Permit Inspections Harnett County

Permit Number: SFD1807-0039

Site Address: **588 ANGEL OAK DR**

2ND FLOOR LAYOUT

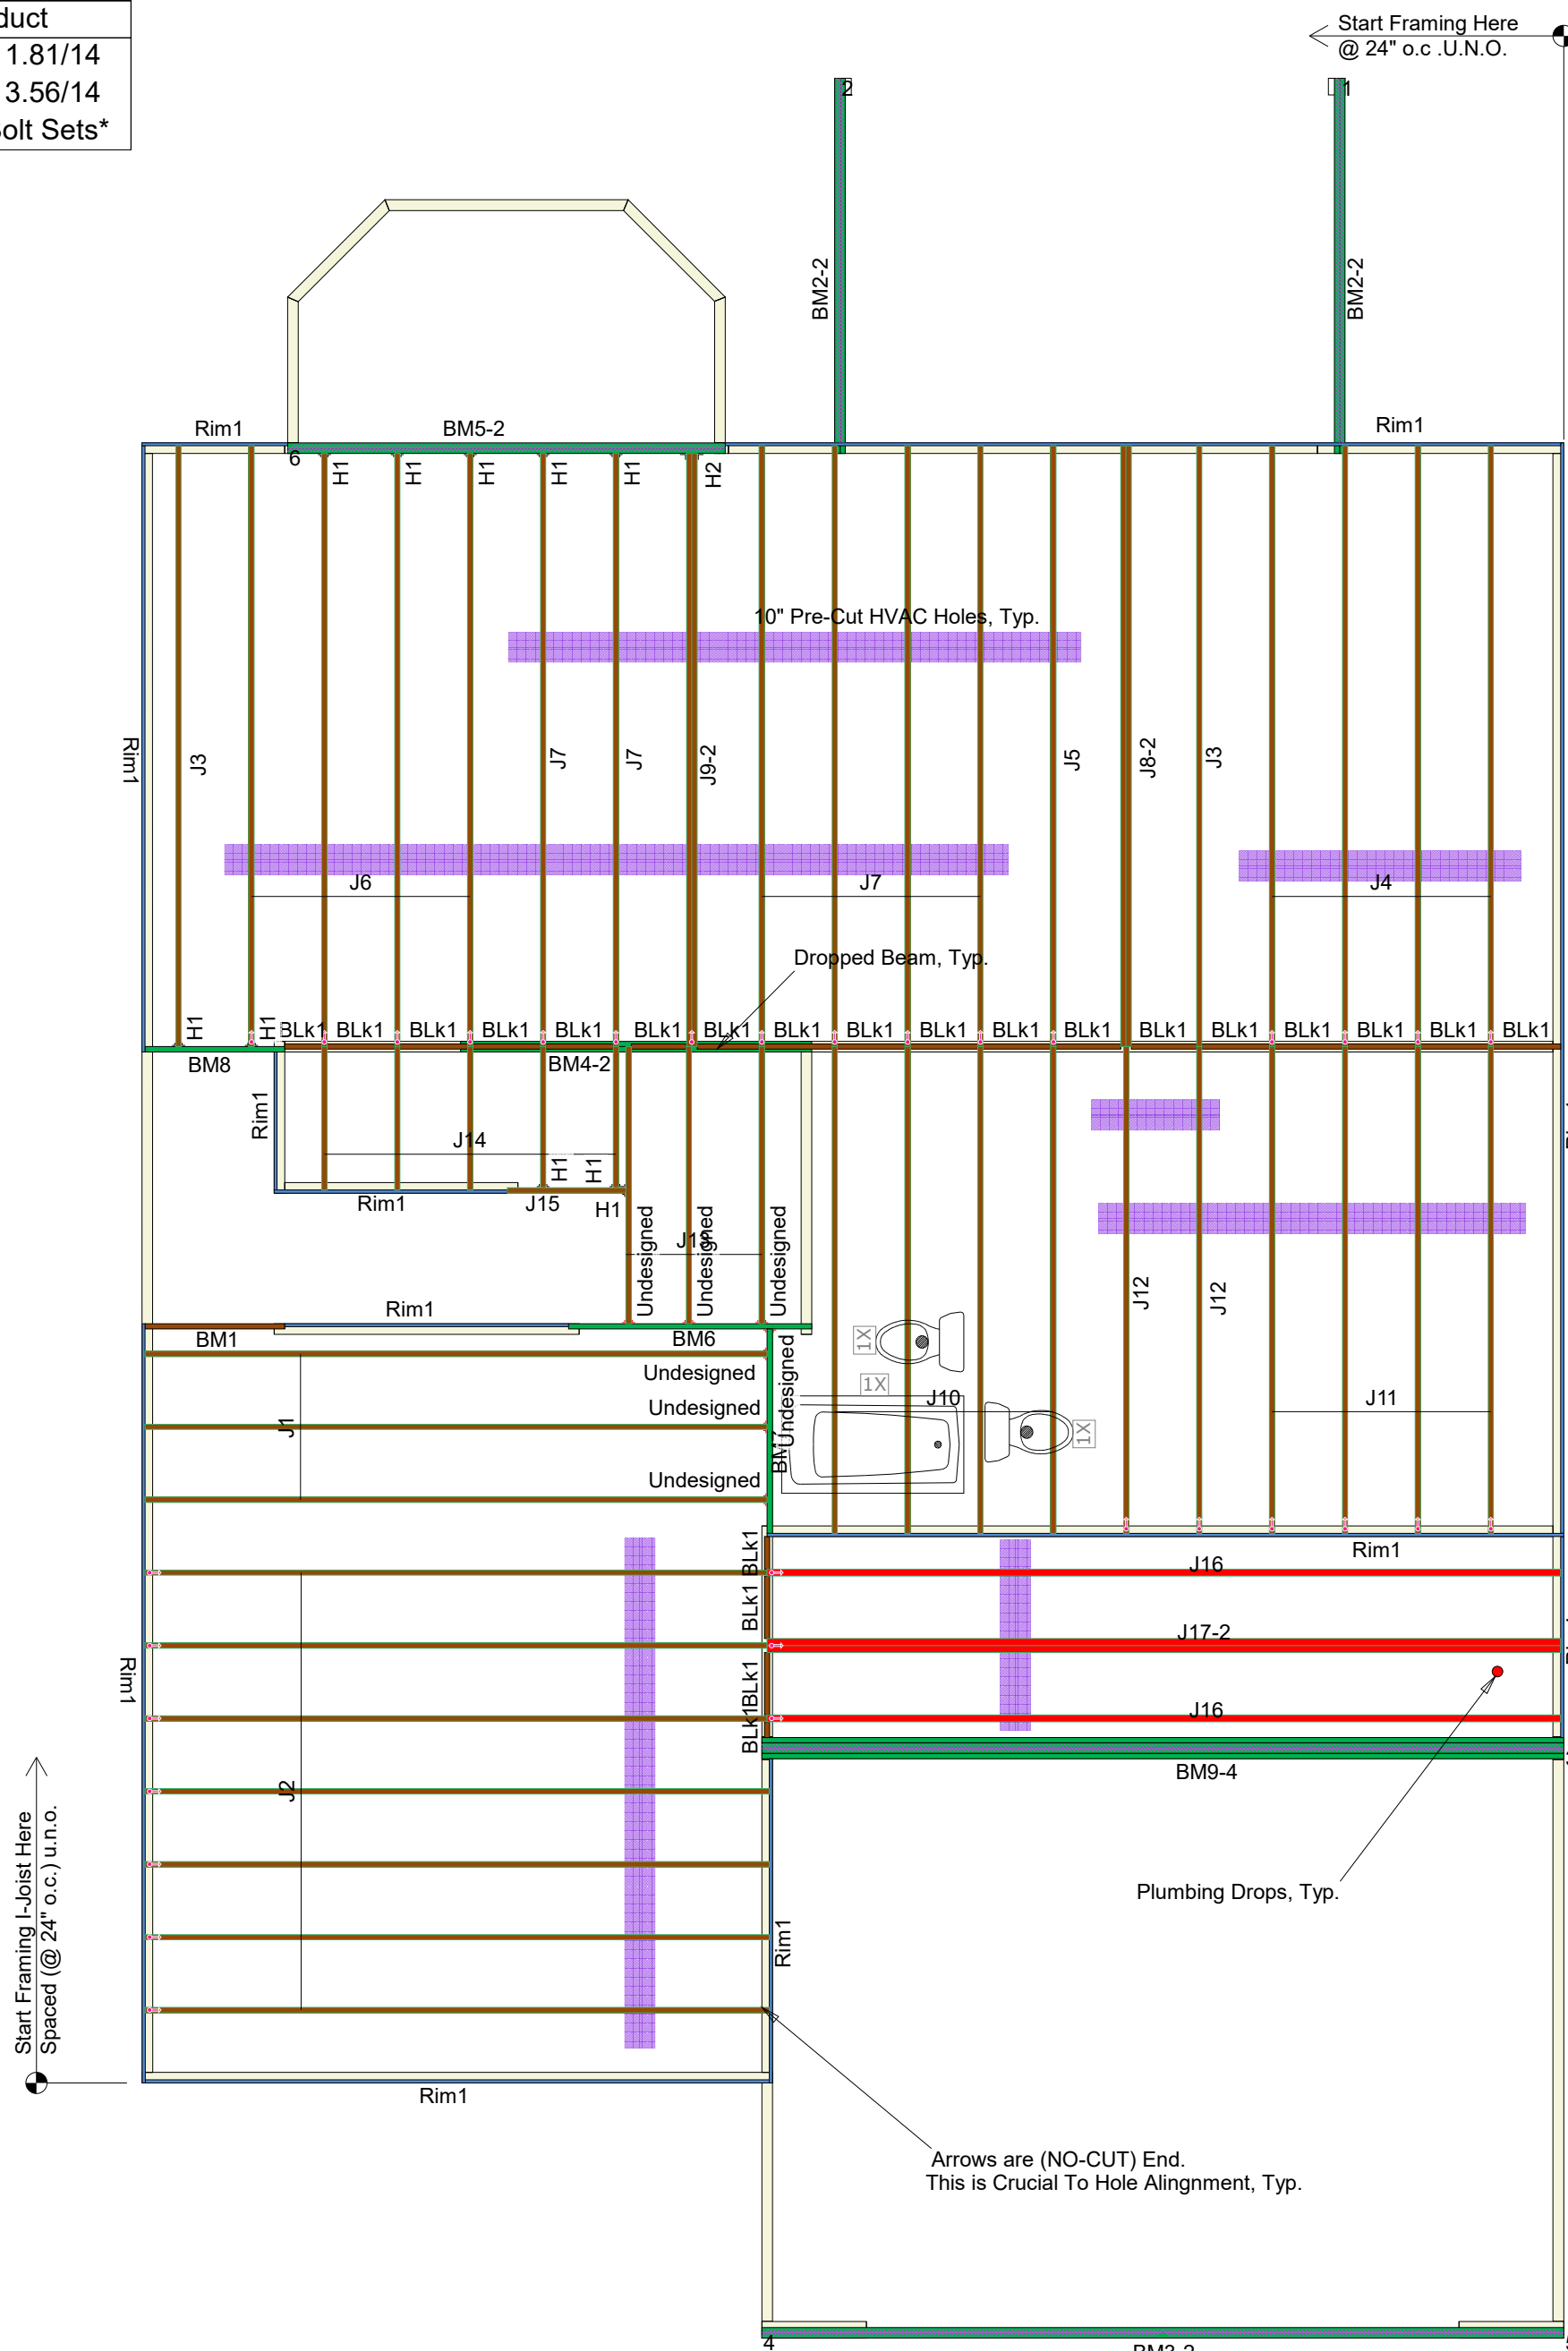
1)Nail 2ply lvl over garage door every 12"per documents.2)Nail Osb at water heater.3)Need paper work for 4ply lvls in garage.4)Nail Osb on end wall in front right bedroom down.5)Furr ceiling down in front right bed closet down for 3" pipe fire block &fire caulk per code.6)Anchor all interior load bearing walls per code.7)Need stud at tub to fasten it to in all bathroom .8)Install I joist hanger correct at bottom of stairs hanger not hanging on lvl.9)Structural nail guard over electrical panel and at top plate in dining room.10)Nail osb on end wall in coat closet at front door.11)fill holes under tub downstairs.12)Fire caulk top of chase over fire box.13)Missing anchor bolts on end wall in living room.14)Roof boots.15)3 ' head of water on drain line test No Water.16)Nail house wrap per installation instructions.17)10 psi on gas line test.Do not Insulate or side
